Preferred Project
Report
MP 08_0112

7-9 Gibbons Street
Redfern
Mixed Use
Development

July 2010

DRAWING:
SOUTH ELEVATION
DRAWING No.:
DA - 1302
ISSUE
C
JOB No.:
5414

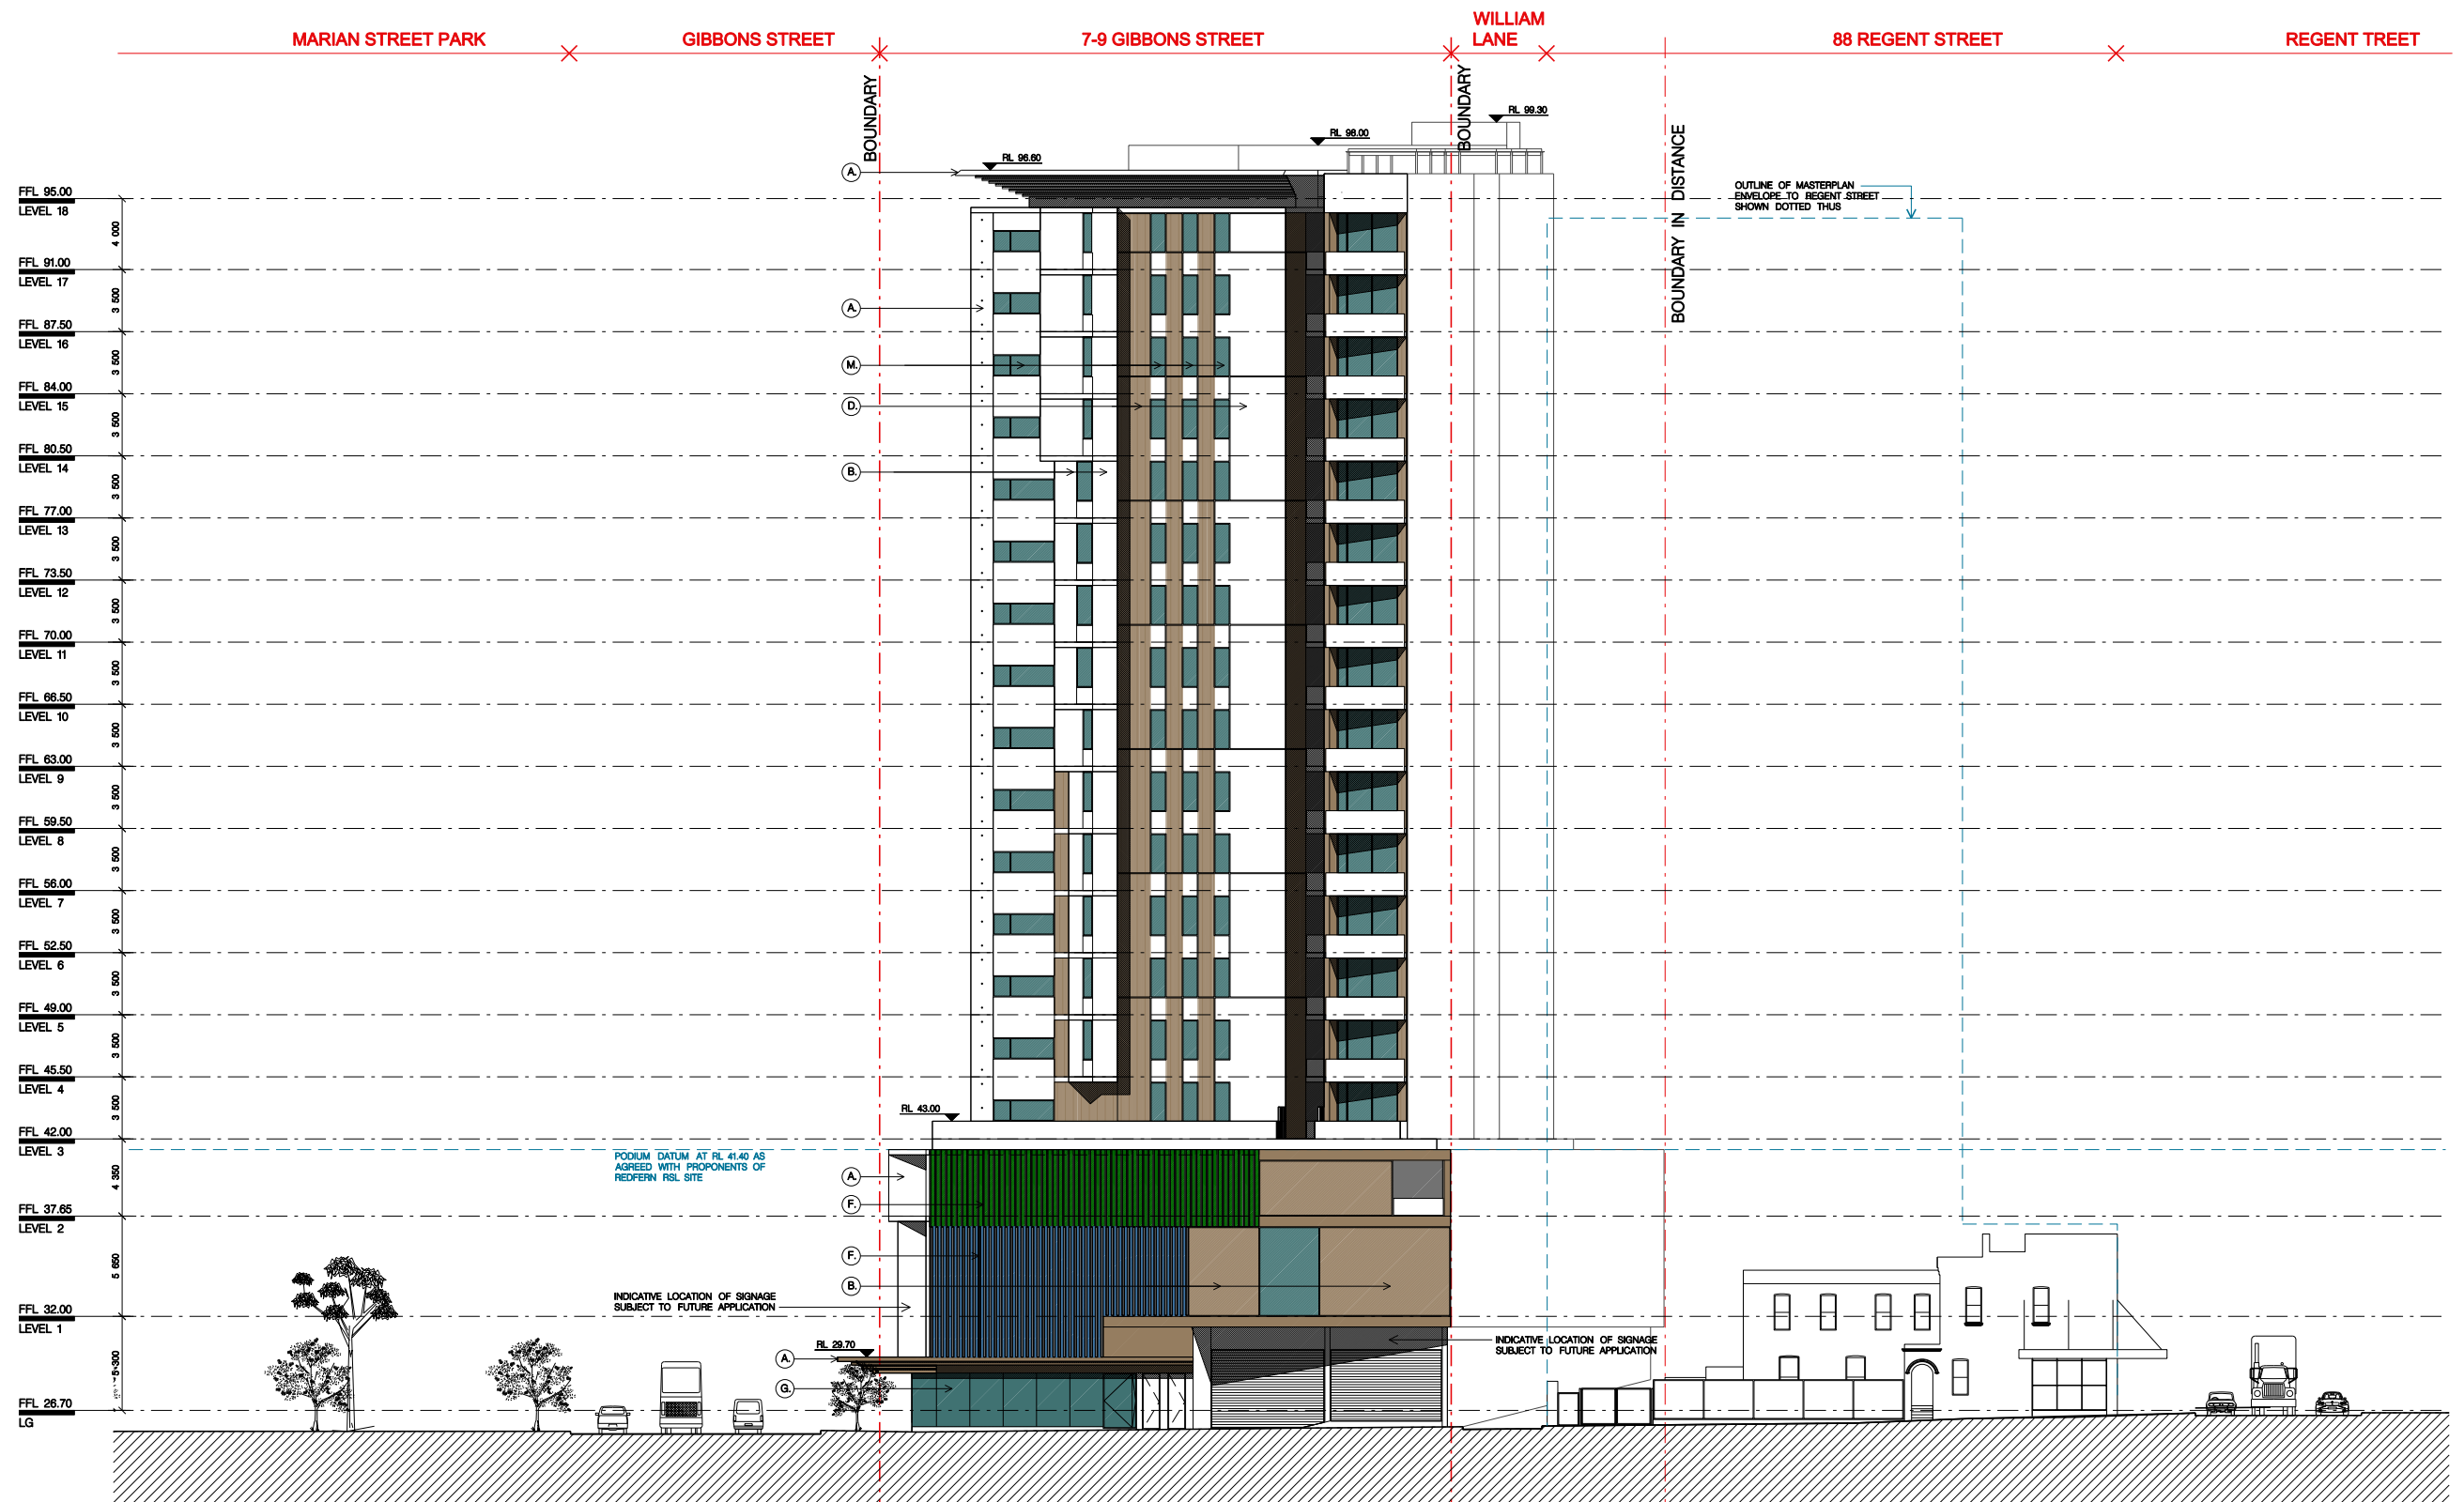
Issue: The Department of Planning and Council raised the following issues associated with the architecture and urban design aspect of the development:

- Consideration of further articulation of the southern facade of the podium element;
- Improve visual surveillance and activity along Marian St and William Lane;
- Design refinement to northern, eastern and southern facades of the tower in terms of materials and colours;
- Provision of separate access for residential and commercial component of the development;

Design amendments have been made to the developed to address the above matters other than activation along the ground level of William Lane as the ground level at that location contains the loading dock for the development.
